City of Albuquerque Stormwater Construction Site Inspection Report

General Information					
ESC File No.	J19E058I	Project Name:	Hotel at Winrock		
NPDES Id. No.	NMRT004SQ	Location:	2160 Louisiana Blvd NE		
4/20/2022	Owner		Owner #2		
Operator	Dreamcatcher, LLC		Winrock Lofts, LLC		
Contact name & title	Deepesh K. Kholwadwala		Fred Gorenz		
e-mail	deepesh@suncapitalhotels.com		gorenz@goodmanrealty.com		
Contact Phone #	505-508-0137		505-401-4650		
COA Inspector	James Hughes		Start/end time	9:30/10:40AM	
Construction Phase:	Rooms are furnished lobby floors and walls incomplete Paving 50%				
Type of Inspection:	Regular	Storm Event	Post Storm Event >0.25"	311/Complaint	Follow Up
Weather at time of inspection?			Temperature: ~ 50		
Estimated date of last storm 0.25" or greater			4/17/2024

TESCP

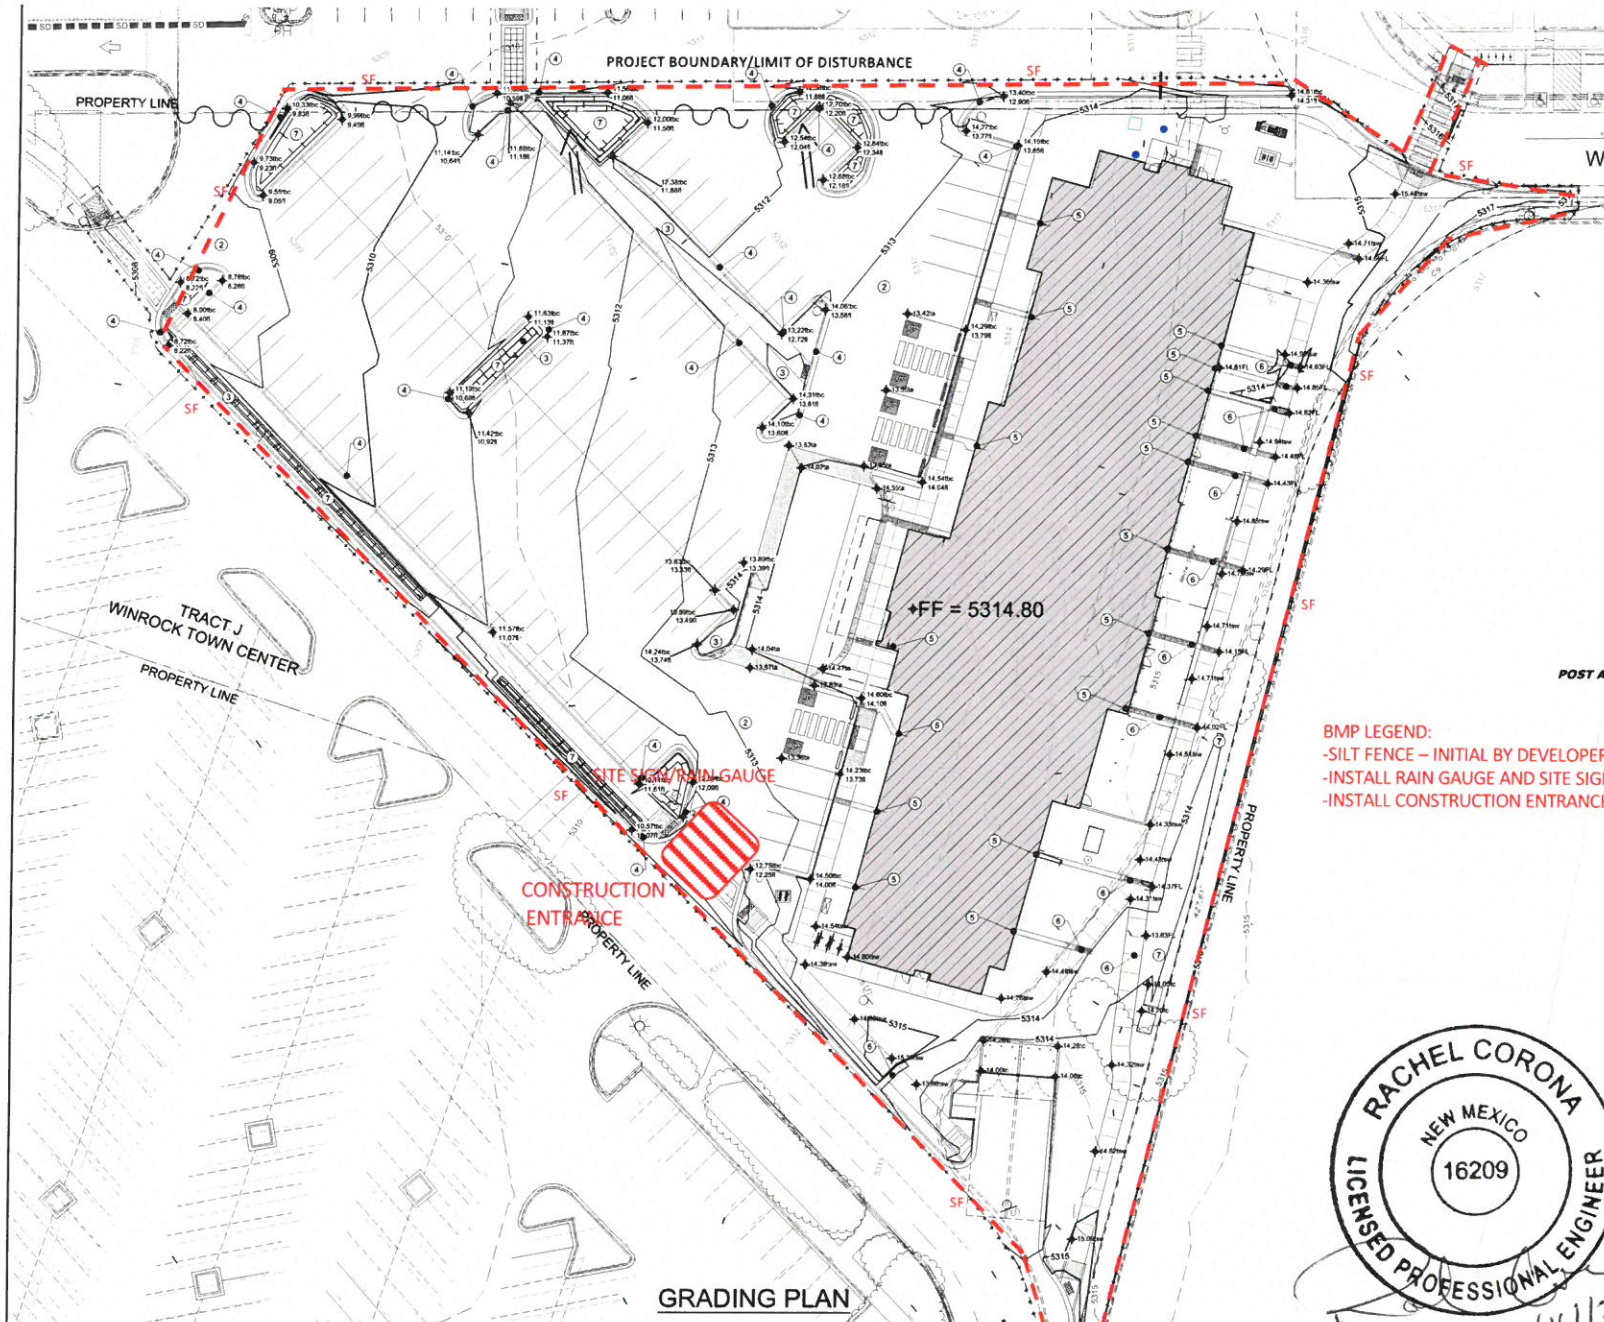
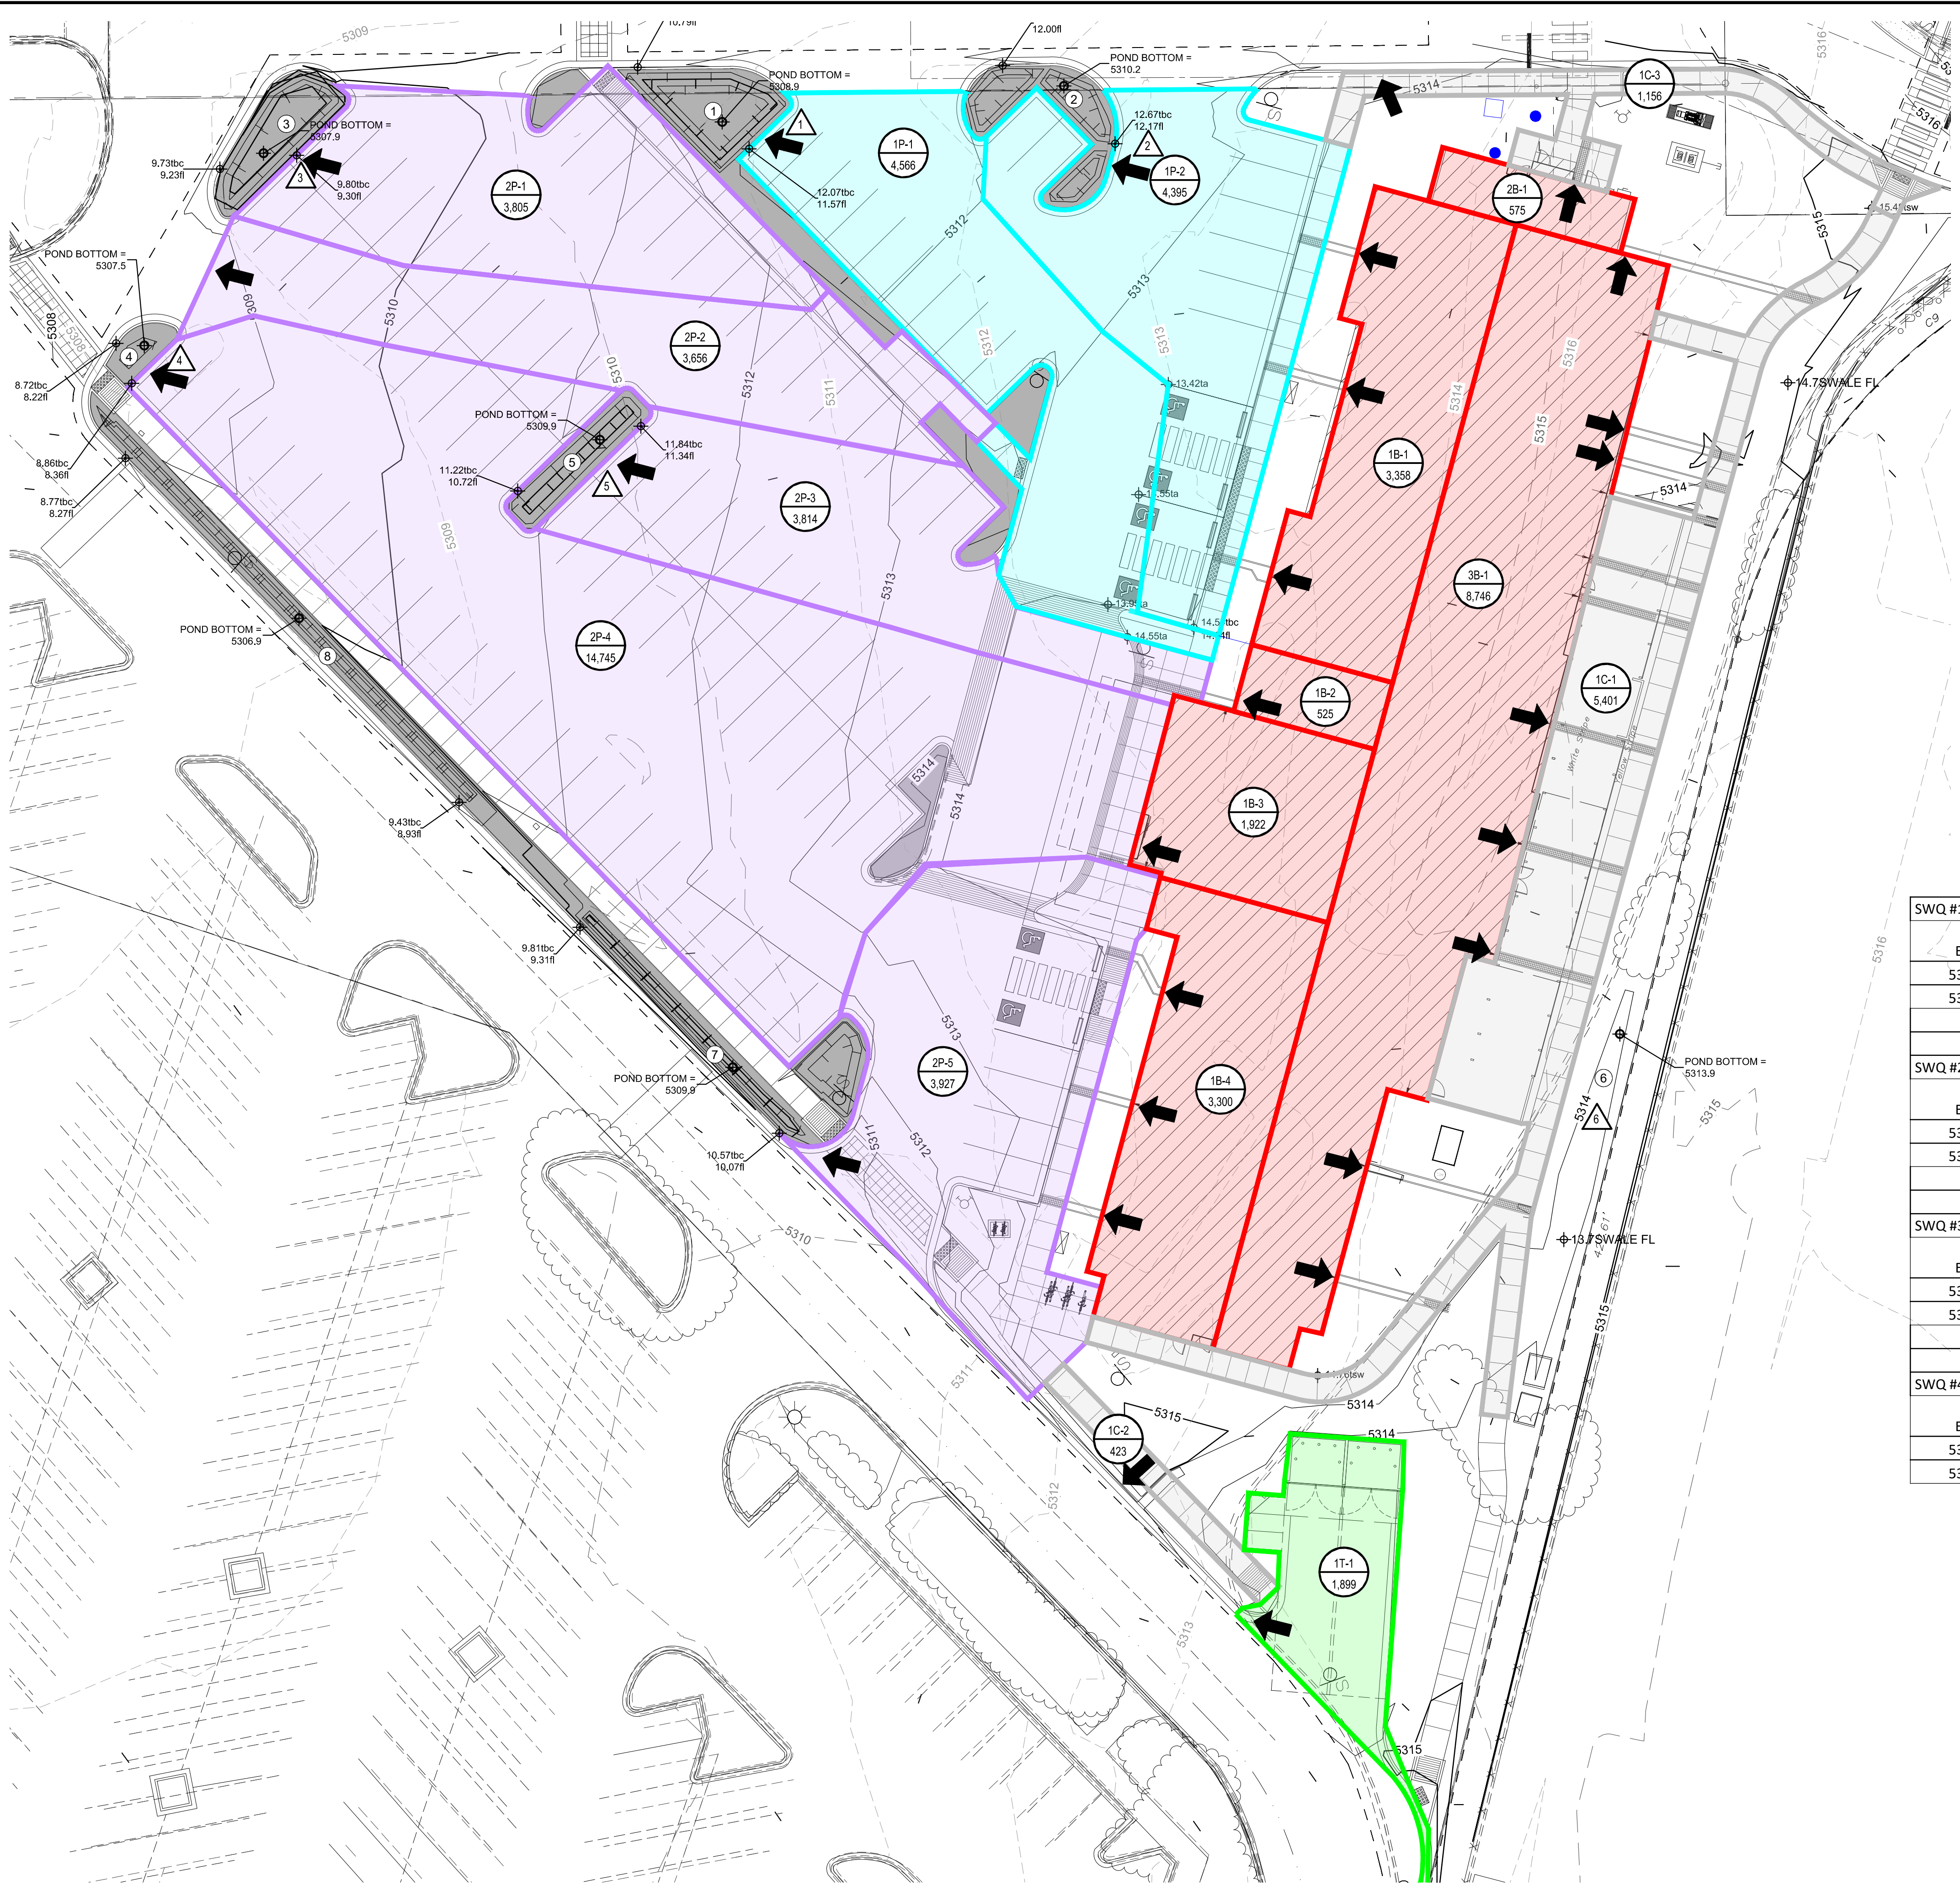
3	<b>BMPs</b> - Erosion and sediment controls (Parimeter Controls) were not implemented and maintained in the parking area on the north side of the site and north of the hotel and in the offsite area of Construction Support Activities northeast of the site to minimize the discharge of pollutants in stormwater from this site in violation of CGP 2.1. The Perimeter Controls were missing in violation of CGP 2.2.3. The inlet protection was missing in the west corner of the Site. <b>Required mitigation:</b> Add perimeter controls around the offsite areas of Construction Support activities and the north parking lot. If at any time you find that a stormwater control needs routine Maintenance, you must immediately initiate the needed maintenance work and complete such work by the close of the next business day. When the problem requires a new or replacement control or significant repair, install the new or modified control and make it operational or complete the repair by no later than seven (7) calendar days from the time of discovery per CGP 5.2.1. Provide inlet protection per CGP 2.2.10.
